**WELWYN HATFIELD BOROUGH COUNCIL
ASSISTANT DIRECTOR (PLANNING)**

DELEGATED APPLICATION

Application No: 6/2022/2901/HOUSE
Location: 42 Daffodil Close Hatfield Hertfordshire AL10 9FF
Proposal: Erection of 3 storey extension to front elevation, ground floor rear extension, garage conversion to granny annex and first floor gym area.
Officer: Ms Elizabeth Mugova

Recommendation: Refused

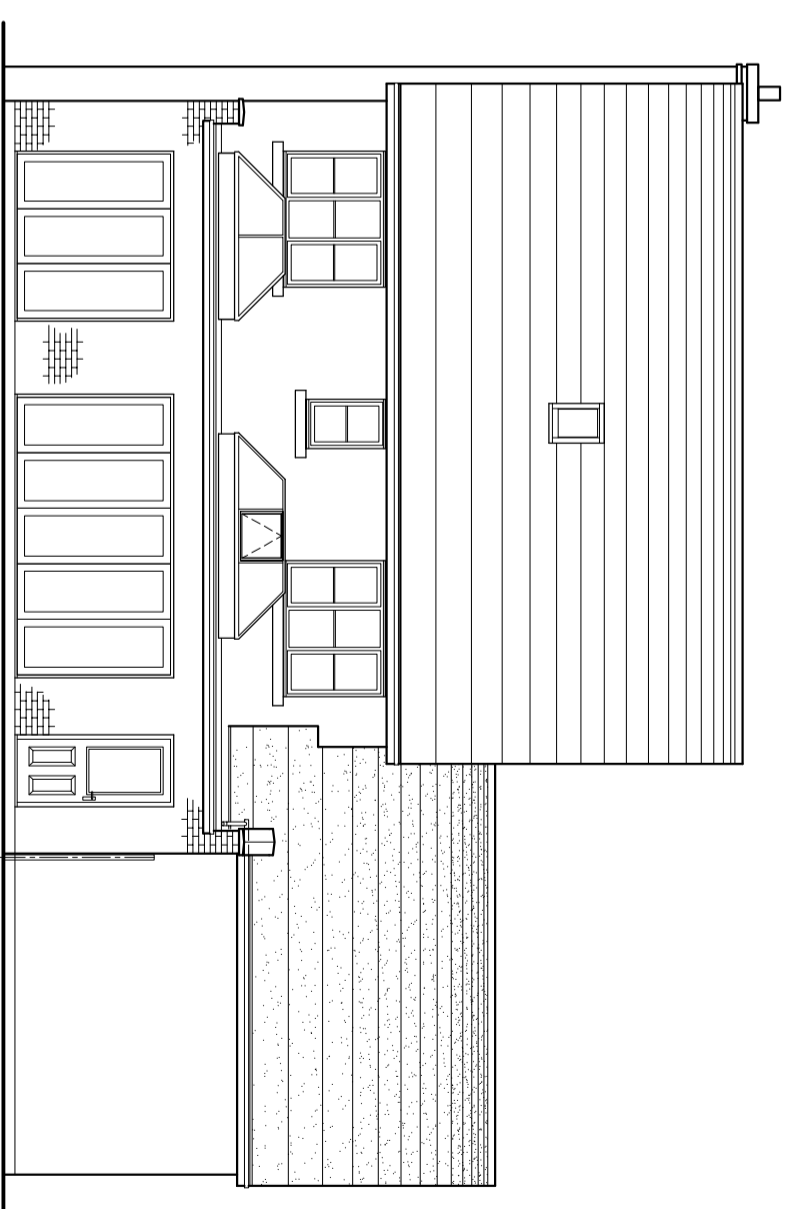
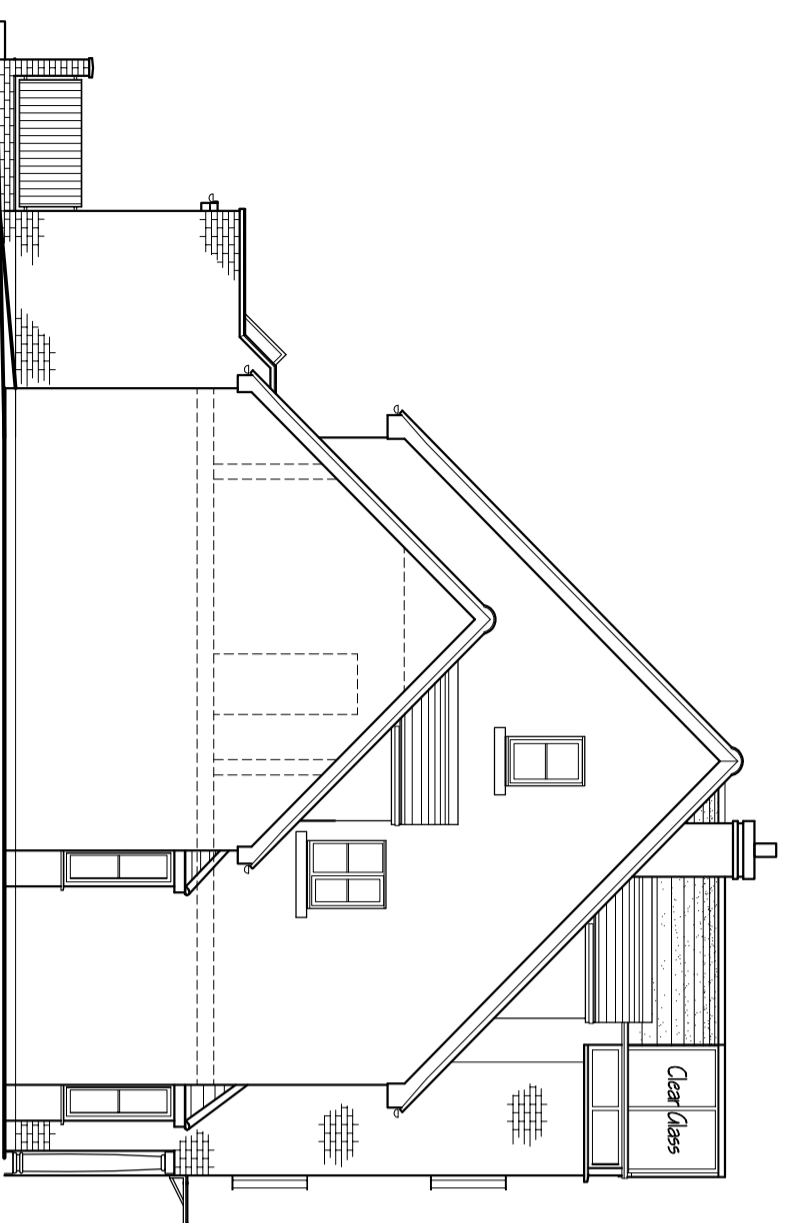
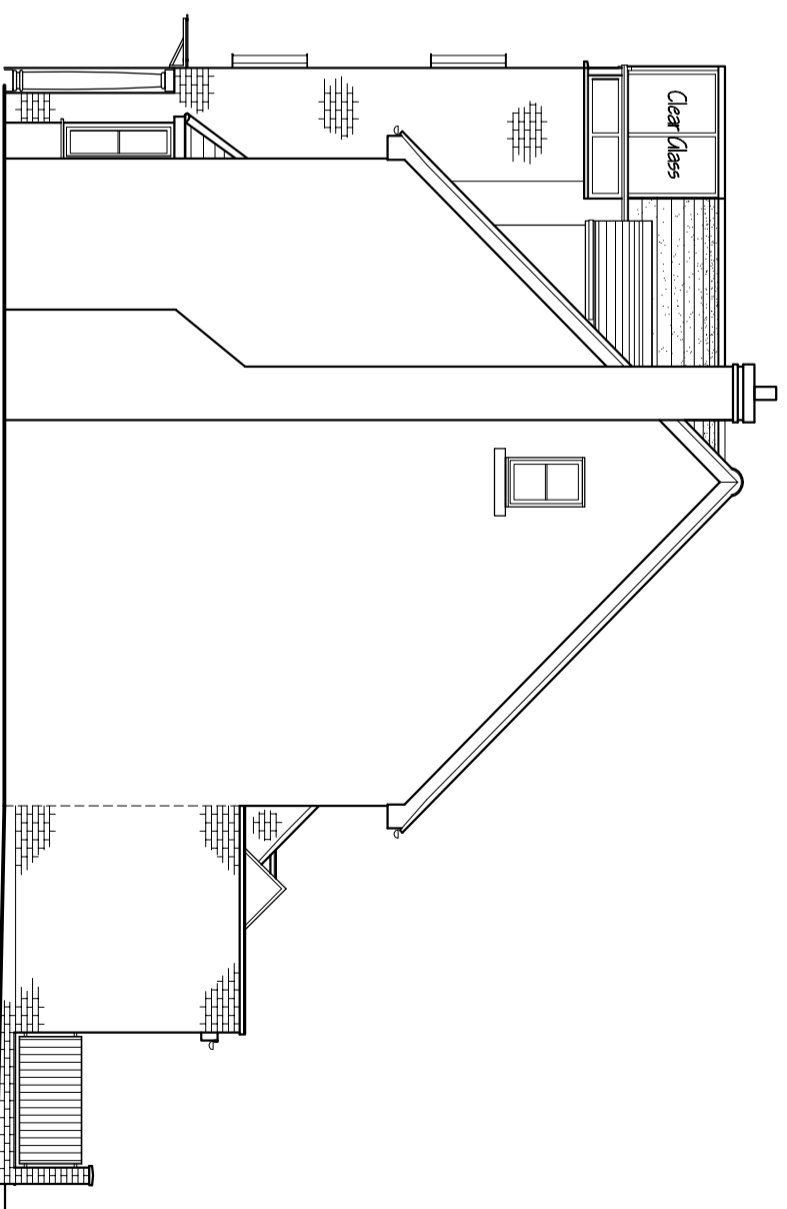
Notwithstanding the single storey rear extension and the use of matching materials, the cluttered arrangement and visual dominance due to the front extension and new bay window would appear incongruous with the character of the host dwelling and the area. It is therefore considered that the proposal would represent a poor standard of design in conflict with local and national policies.

The proposed front dormers above the existing garage would result in unacceptable overlooking of No. 40 Daffodil Close rear garden. It is therefore considered that the front dormers would result in a loss of privacy and harm the living conditions of the neighbouring occupiers, in conflict with local and national policies.

By reason of its siting, size, scale and design the proposed three storey front extension and new bay window would result in a cluttered and incongruous form of development, harmful to the character and appearance of the host dwelling are surrounding area. Accordingly, the proposal would represent a poor standard of design in conflict with District Plan Policies D1, D2 and GBSP2; Policy SP9 of the Emerging Local Plan; the Supplementary Design Guidance; and the National Planning Policy Framework.

The proposed front dormer windows by reason of their siting would result in unacceptable overlooking of the rear garden of No. 40 Daffodil Close. Consequently, the proposal would harm the living conditions of the neighbouring occupiers, in conflict with Policies D1 of the Welwyn Hatfield District Plan 2005; Supplementary Design Guidance 2005; Policy SADM11 of Draft Local Plan Proposed Submission August 2016; and the National Planning Policy Framework.

Project	PROPOSED 3 STOREY EXTENSION TO FRONT ELEVATION AND GROUND FLOOR REAR EXTENSION AND GARAGE CONVERSION TO 'GRANNY' ANNEXE AND FIRST FLOOR GYM AREA.
Address	42 DAFFODIL CLOSE, HATFIELD, HERTS, AL10 9PF
Title	BLOCK PLAN AND PROPOSED PATIO AREA TO REAR GARDEN - SHEET 5

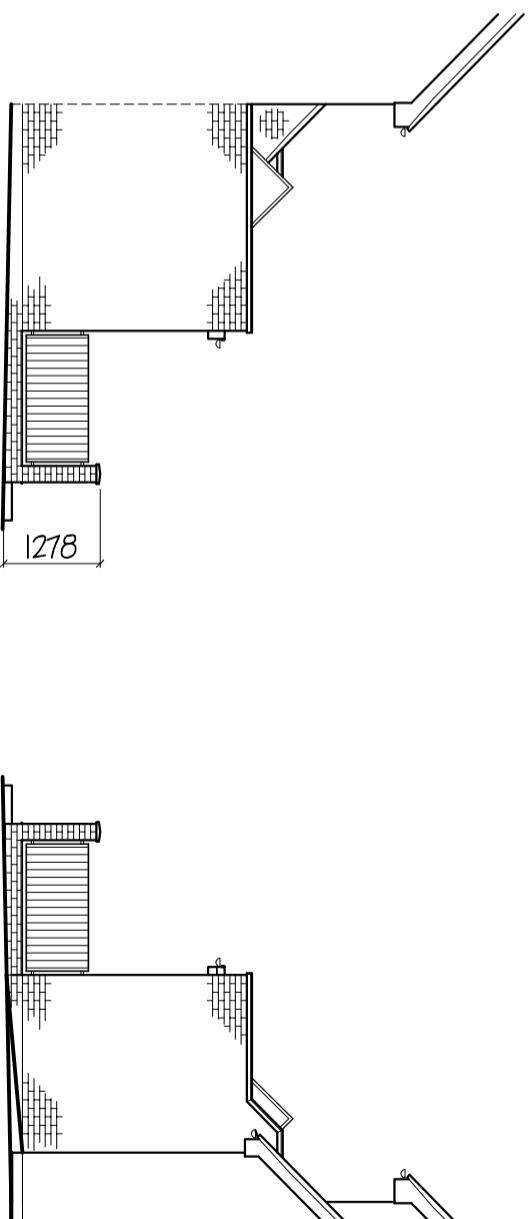
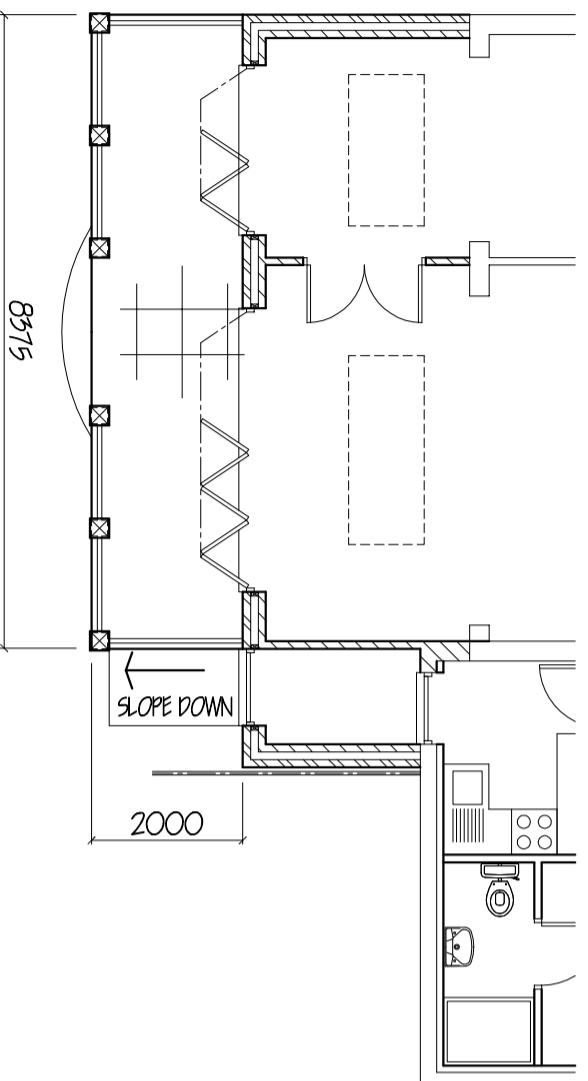
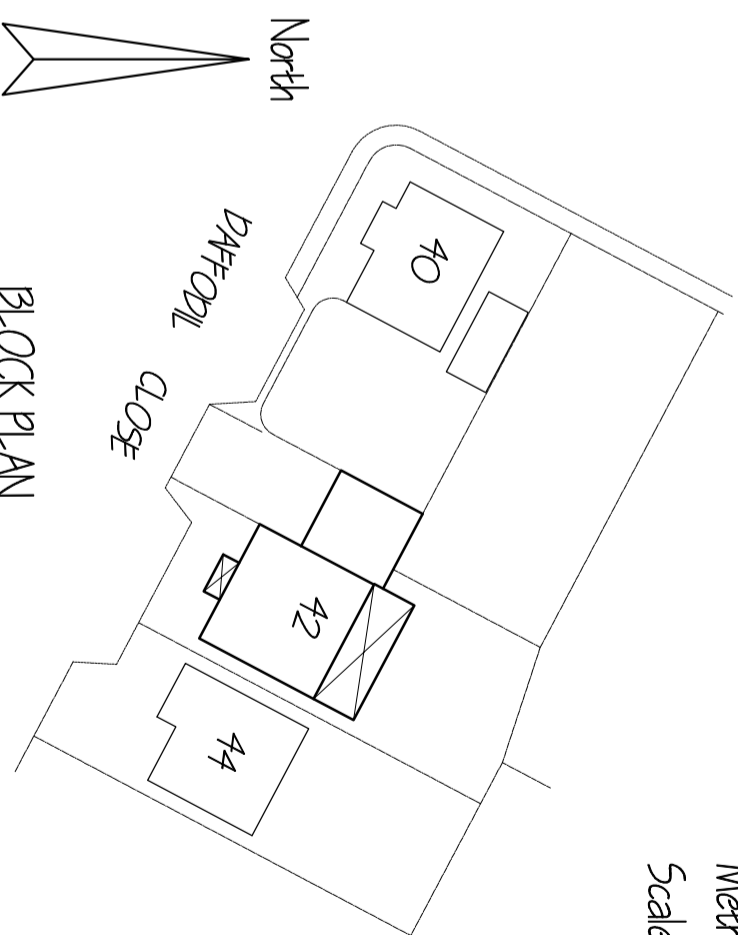
To the rear of the property, the proposal is to create a single storey extension and patio area. By virtue of its height and depth, the rear extension would appear subordinate to the host dwelling. It is therefore considered that this element of the proposal would not detract from the character and appearance of the host dwelling and the surrounding area.

Title PROPOSED FLOOR PLANS - SHEET 3

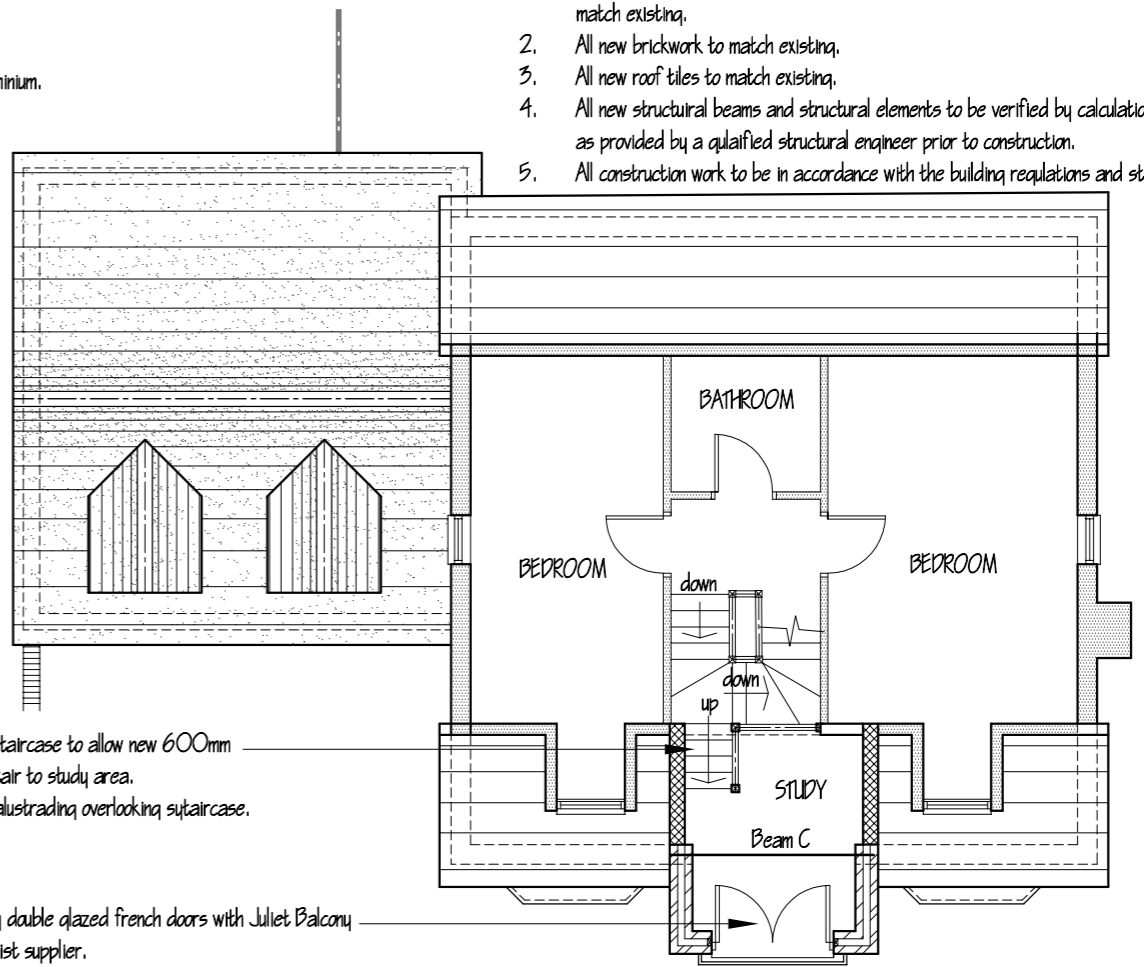
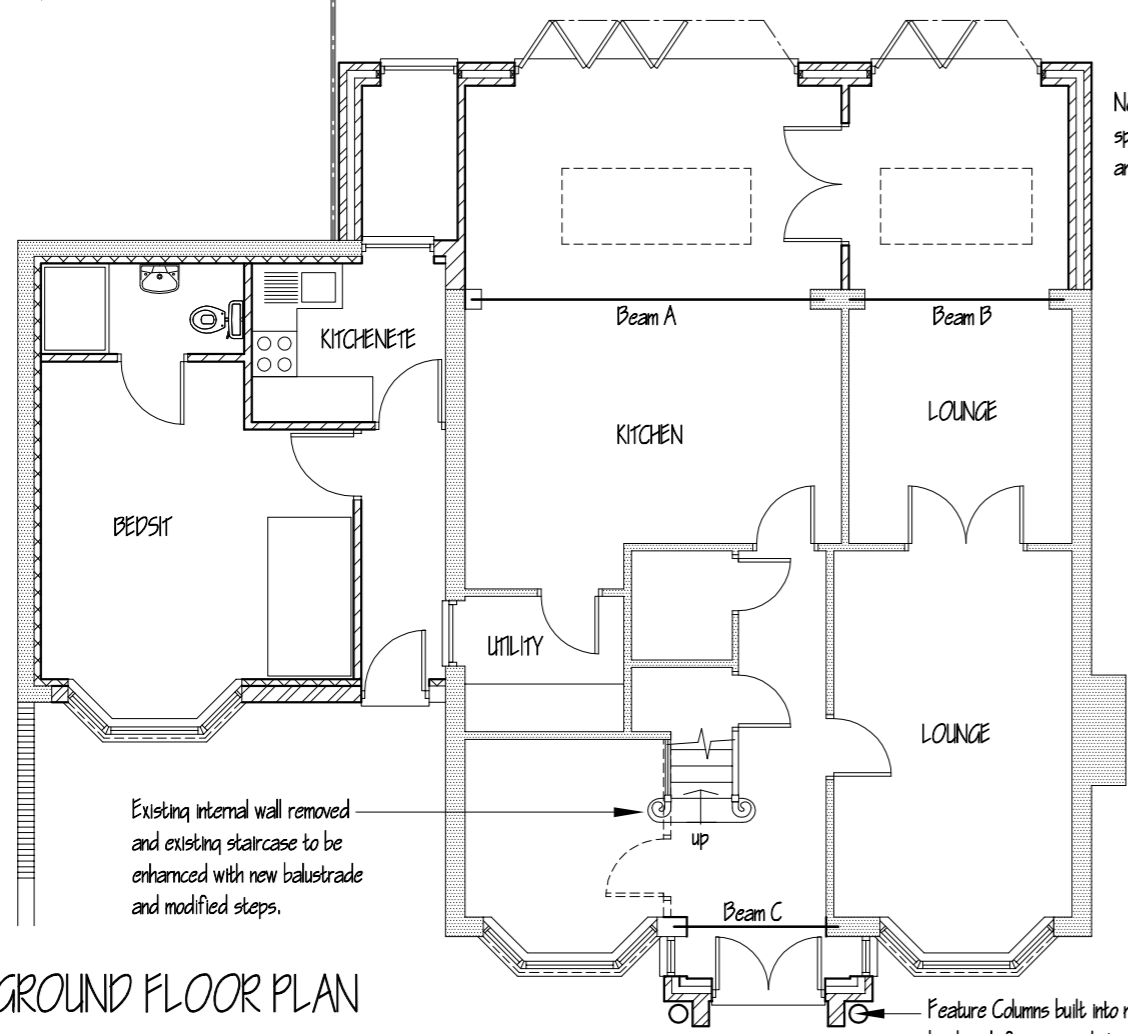
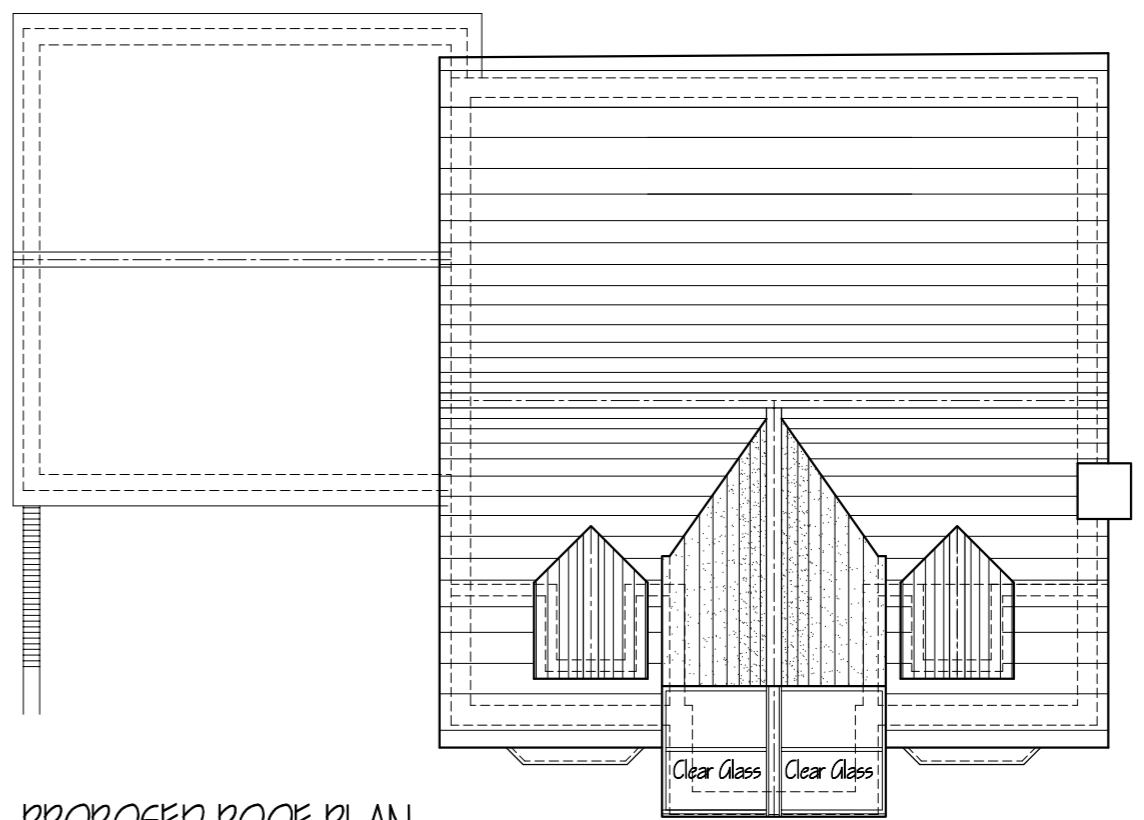
The application property fronts a play area, as such, it is not considered that the proposed Juliet balconies would have any adverse impact in terms of loss of privacy.

The rear garden of No. 40 Daffodil Close backs onto the garage of the application site and there is approximately 10m between the flank wall of the garage and the rear windows at this neighbouring property. The eaves of the garage would only increase marginally (by approx. 0.5m) and the increase in height would relate to a roof which narrows to a ridge, therefore, the apparent increase in bulk would be limited when viewed from No.40. Also, in terms of outlook from No.40, it is notable that the extension would be viewed against the backdrop of the host dwelling. It is therefore considered that the alteration to the garage would not result in material overshadowing or loss of light to neighbouring occupiers.
